SOUTH TEES DEVELOPMENT CORPORATION (STDC)

NET ZERO TEESIDE DEVELOPMENT CONSENT ORDER

RESPONSE TO EXAMINING AUTHORITY'S FIRST WRITTEN QUESTIONS

CUTLINE SHEET 11
CUTLINE SHEET 6

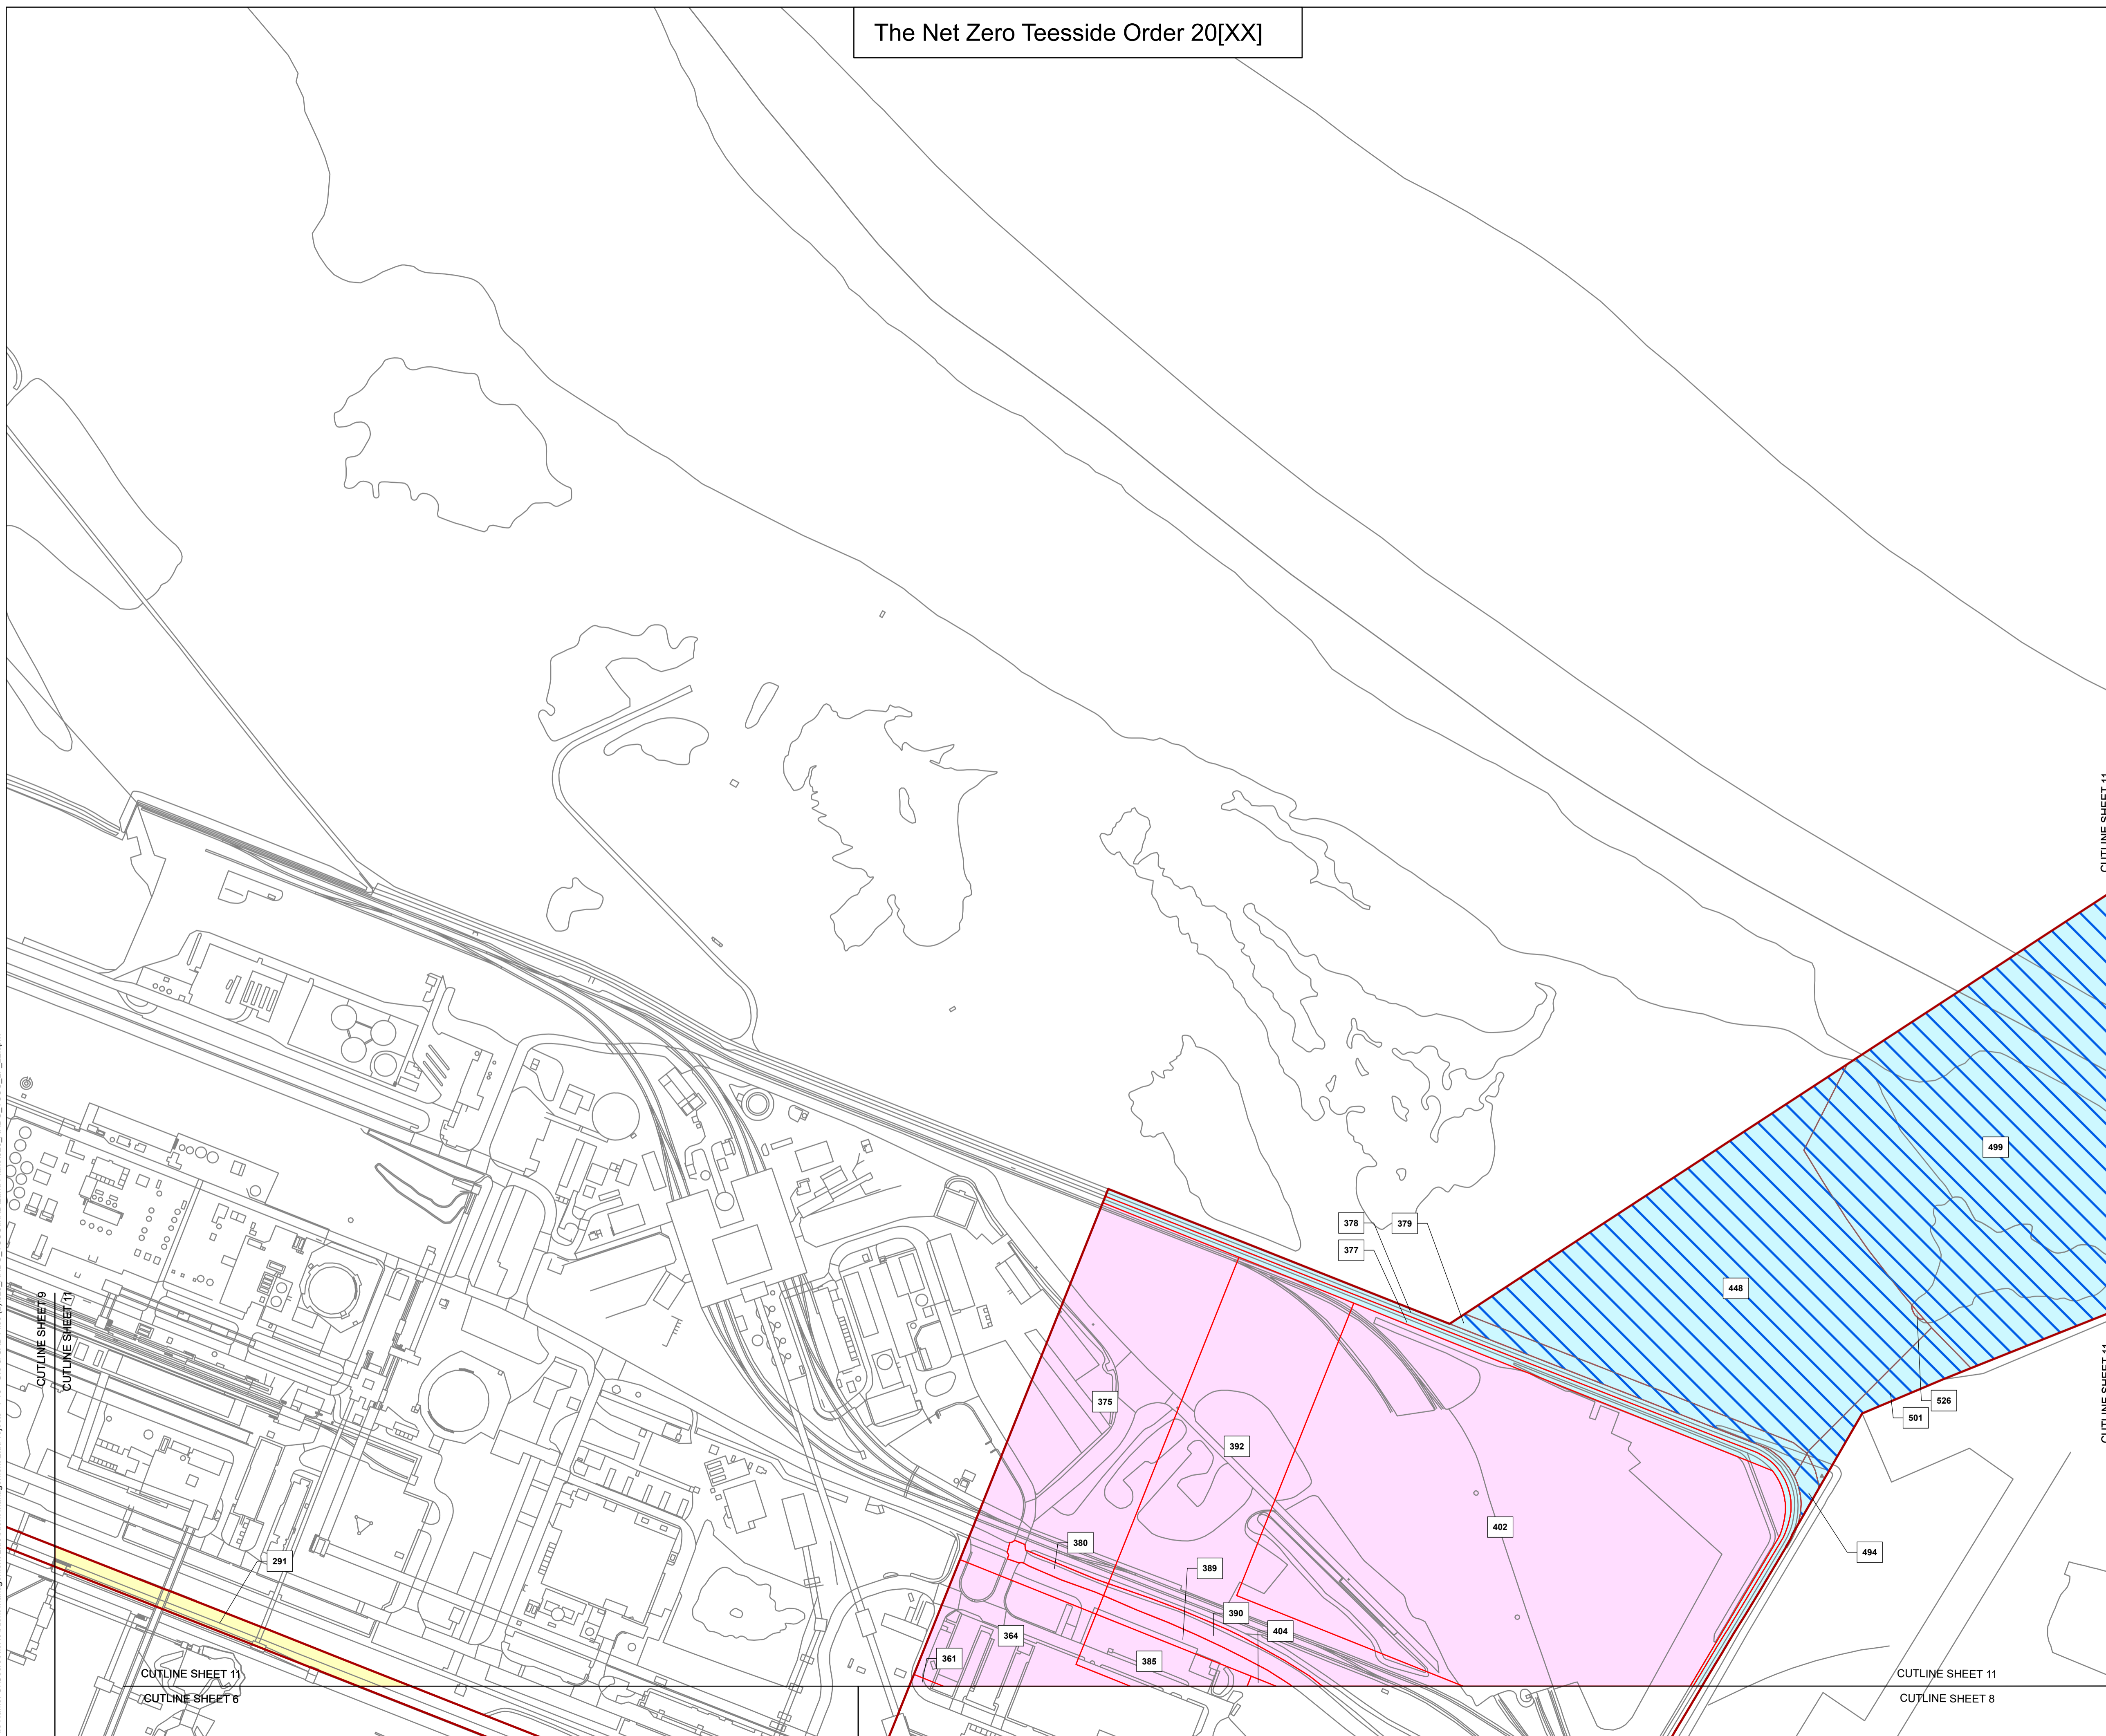
<p>the Guide to Land Plan Plots document refers to 9A. STDC would appreciate clarity from the Applicants on what work it is seeking to carry out on its land.</p> <p>Plots 298, 299, 309 (Construction access from Redcar Bulk Terminal) and related plots (Sheet 6 of Land Plans) – While STDC support the reduction in rights in this area, STDC continues to resist use of Freeport land for laydown and consider it disproportionate. STDC require the laydown land to be removed from the scope of the draft Order limits. STDC is supportive (in principle) of the Applicants use of estate roads/accesses, subject to the rights of STDC to alter them (and provide reasonable alternatives) in the future to make way for further development. STDC require sufficient controls within the draft Order via protective provisions or requirements to protect its interests if an agreement cannot be reached.</p> <p>Plot 342 (Sheet 8 of Land Plans) – STDC understands from its discussions on the option agreement with the Applicants that not all of this land is required. STDC expects the Applicants to reduce the extent of the Order limits accordingly, to reflect the private agreement between the parties.</p>
